Our ref: NO/2021/113750/02-L01
Your ref: 3/2021/0731
Date: 05 October 2021

**REDEVELOPMENT OF THE EXISTING EDUCATIONAL FACILITY INCLUDING PART DEMOLITION OF THE EXISTING INFANT SCHOOL TO PROVIDE A STANDALONE NURSERY FACILITY, TOGETHER WITH THE REMODELLING OF, AND EXTENSION TO, THE EXISTING JUNIOR SCHOOL, AND ERECTION OF A NEW INFANT BLOCK TO THE REAR OF THE BUILDING, ALONGSIDE ADDITIONAL CAR PARKING. SOFT AND HARD LANDSCAPING TREATMENT AND VEHICULAR ACCESS WORKS OFF GREENACRE STREET.
ST JAMES C OF E PRIMARY SCHOOL, GREENACRE STREET, CLITHEROE, BB7 1ED.**

Environment Agency position

Figure 3 - Location of Infant Block and 2D Levels

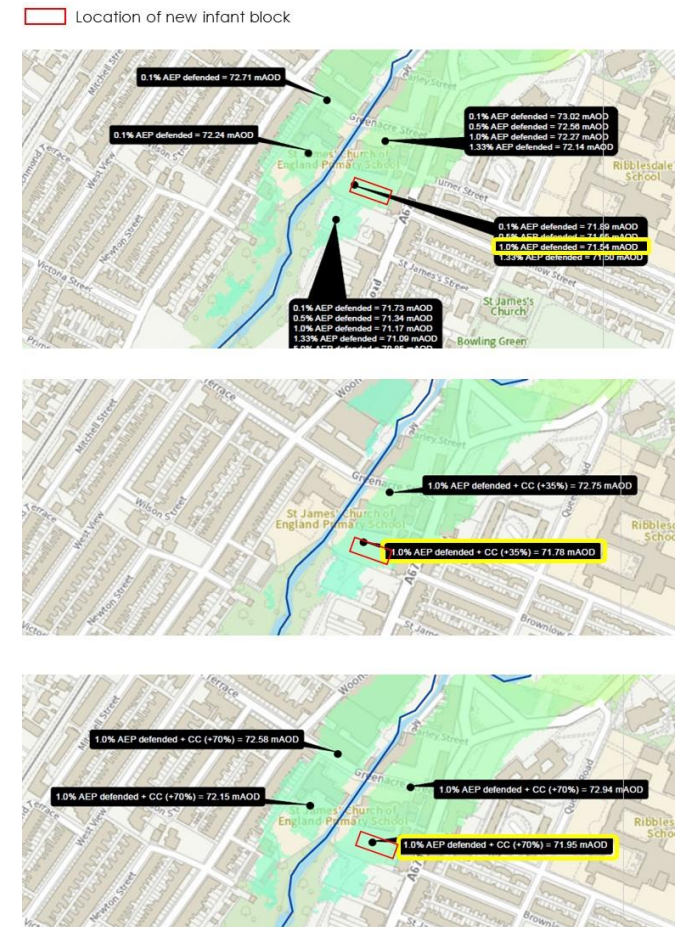
The proposed new building and extensions on the east bank will be built in undefended Flood Zone 3. The FRA must assess the impact of the development on flood risk which, in accordance with Paragraph 159 of the NPPF, must not result in increasing flood risk beyond the boundary of the site.

To overcome our objection, the applicant should submit a revised FRA and plan which addresses the points highlighted above.
